# CITY OF ALBUQUERQUE

August 6, 2018

RE: **Jefferson Hotel**  
**Restaurant Ln NE**  
**Grading Plan Stamp Date: 7/30/18**  
**Drainage Report Stamp Date: 7/30/18**  
**Drainage File: F17D044C**

Based on the submittal received on 7/31/18, the grading plan and drainage report cannot be approved for building permit until the following are corrected:

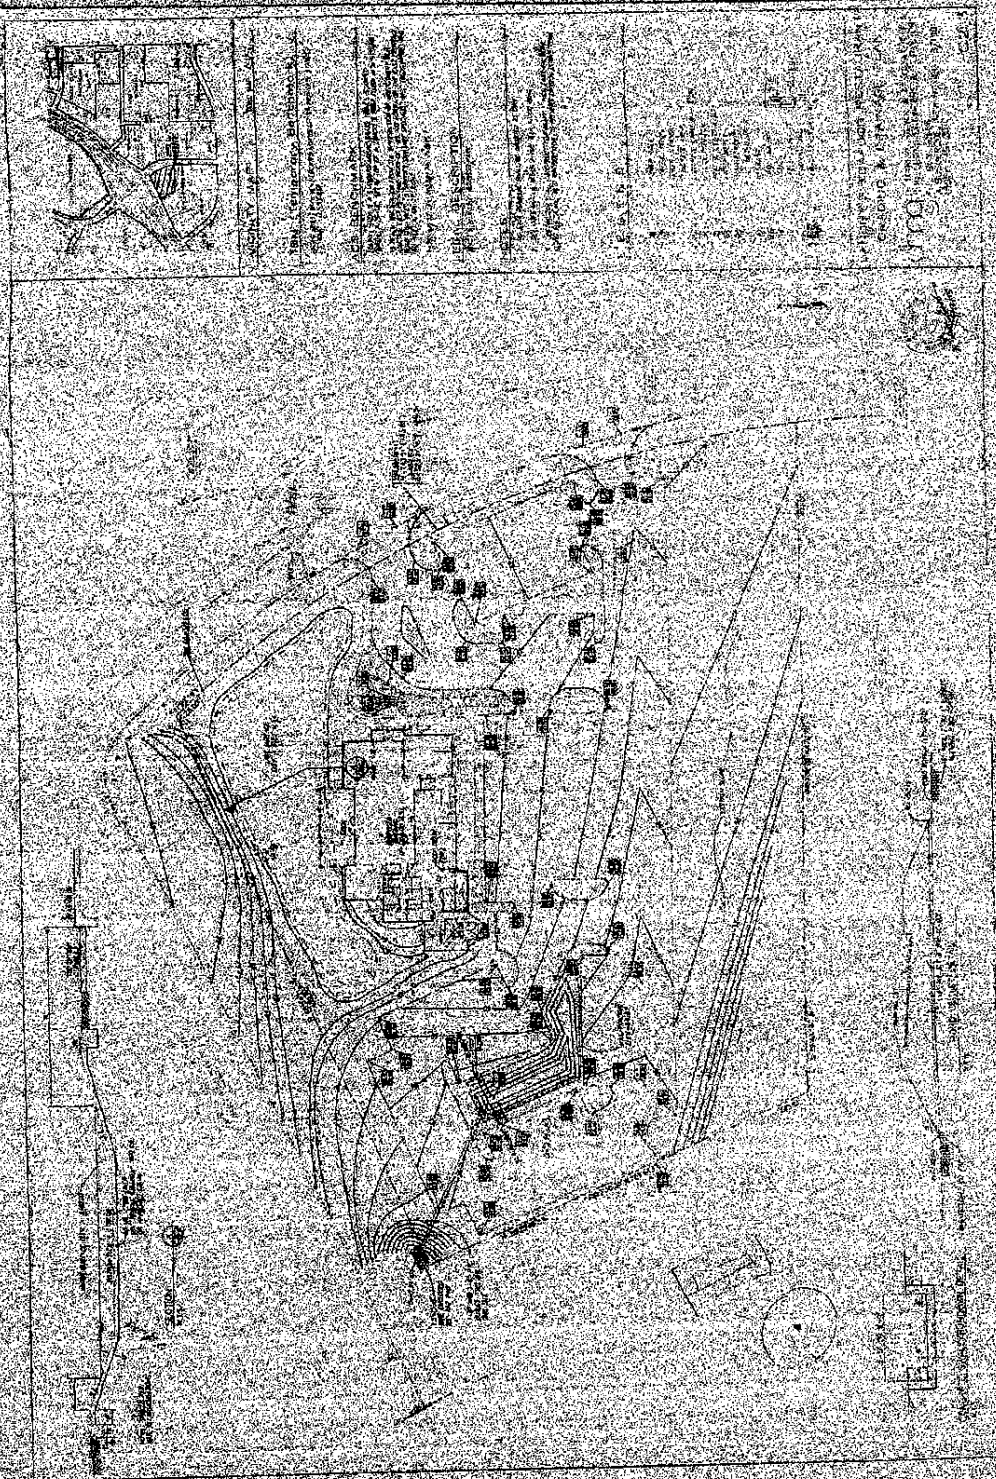
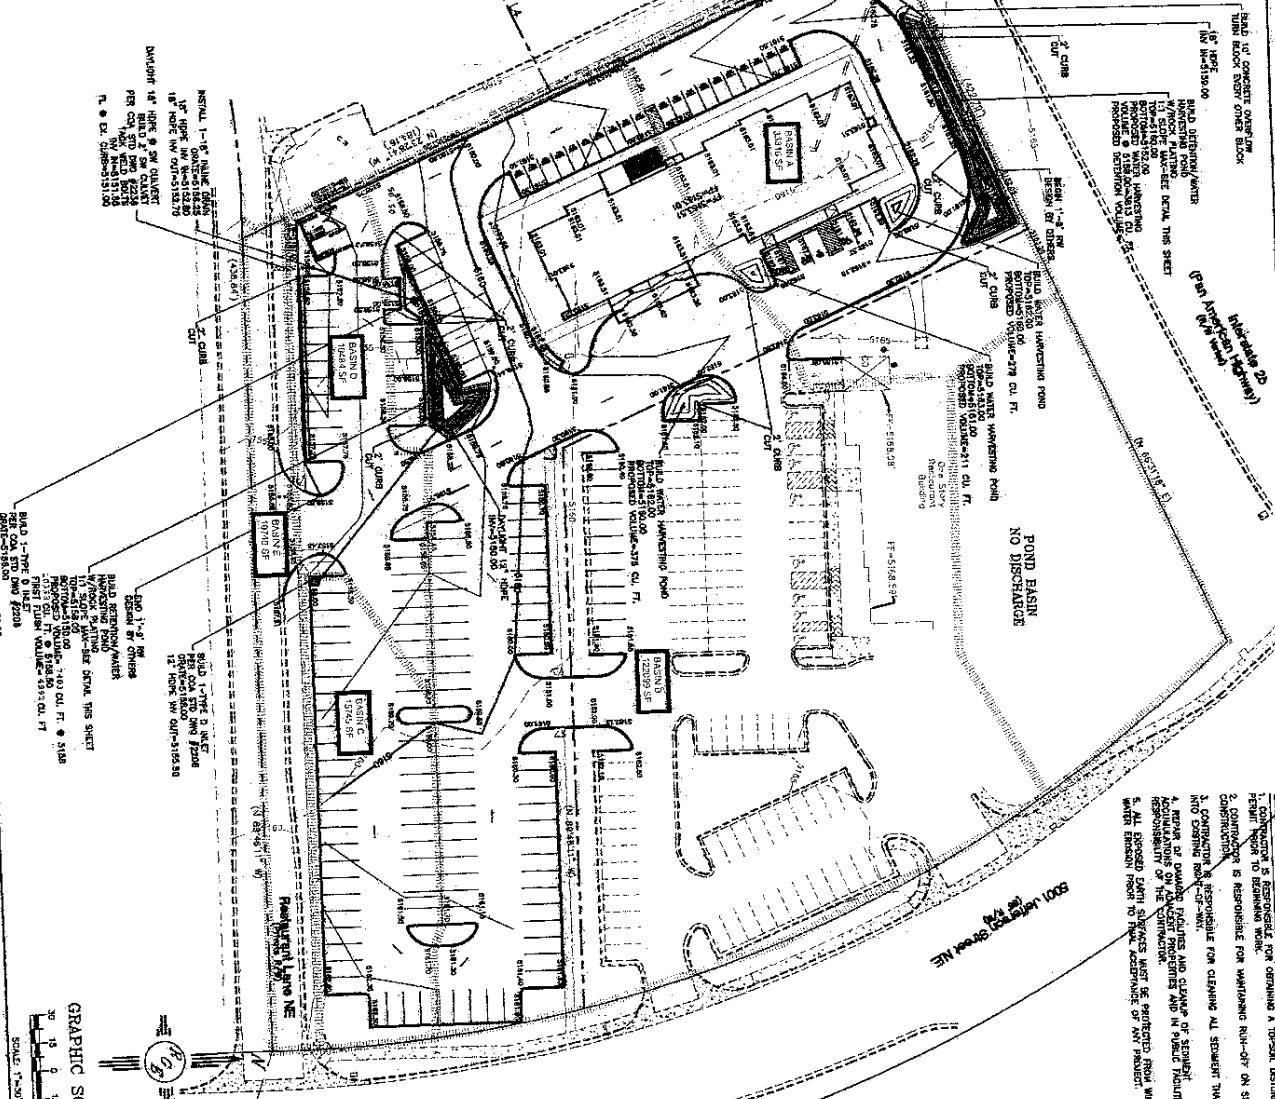
1. The Type C inlet at the NW corner should be removed as it allows surface flows to bypass the first flush pond. Stormwater draining to this low spot will need to be routed to the pond first. Also the 4" orifice plate isn't necessary on this outlet:
